Response to Submissions Report – Newcastle Power Station, Tomago (SSI-9837)

Newcastle Power Station, Tomago (SSI-9837) – Response to submissions

**Newcastle Power Station Project (CSSI 9837) Response to Submissions
Further Information Still Required by the Environment Protection Authority**

Figure 6.3: ISR vs in-stack NO_x concentration from filtered US EPA ISR database

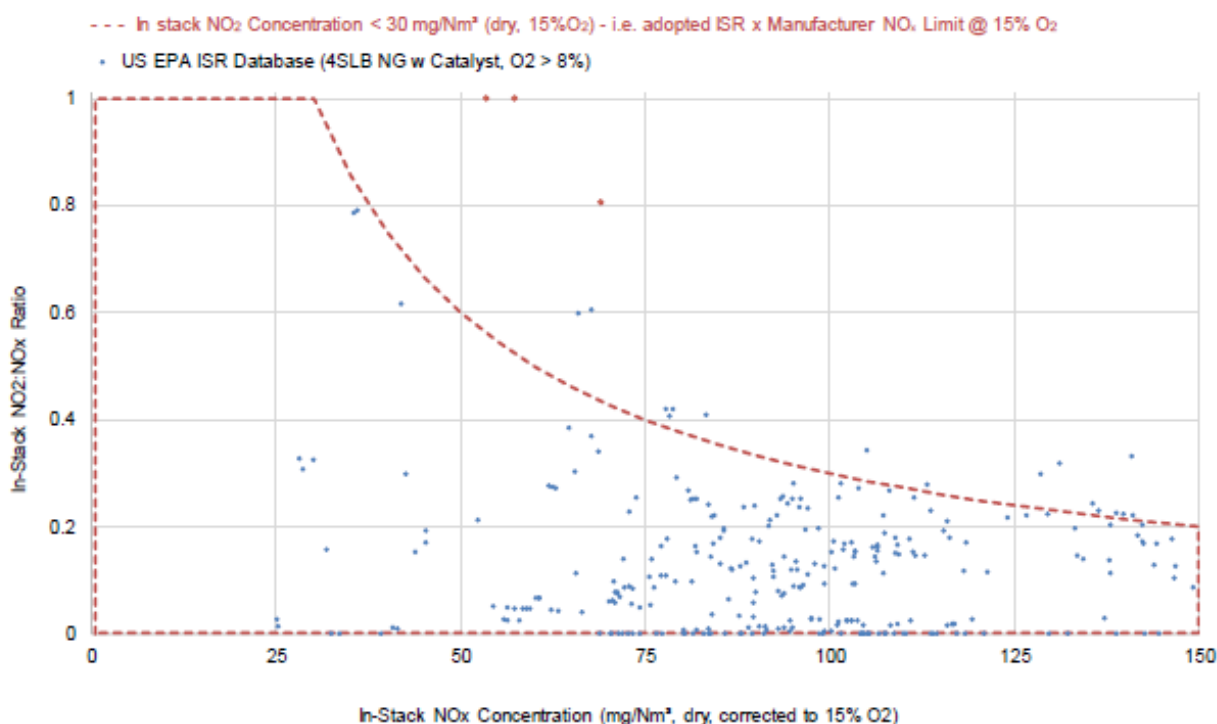
Achievable emission levels for NO_x have been demonstrated to be significantly lower than those referenced and proposed in the RTS AQIA benchmarking. This is demonstrated in the AQIA's figure 6.3 which shows in stack NO_x emissions, which are not necessarily best practice, are generally far less than 100 mg/m³ (@ 15 % O₂) and therefore the proposed 150 mg/m³ is not best practice (Figure 6.3 reproduced below).
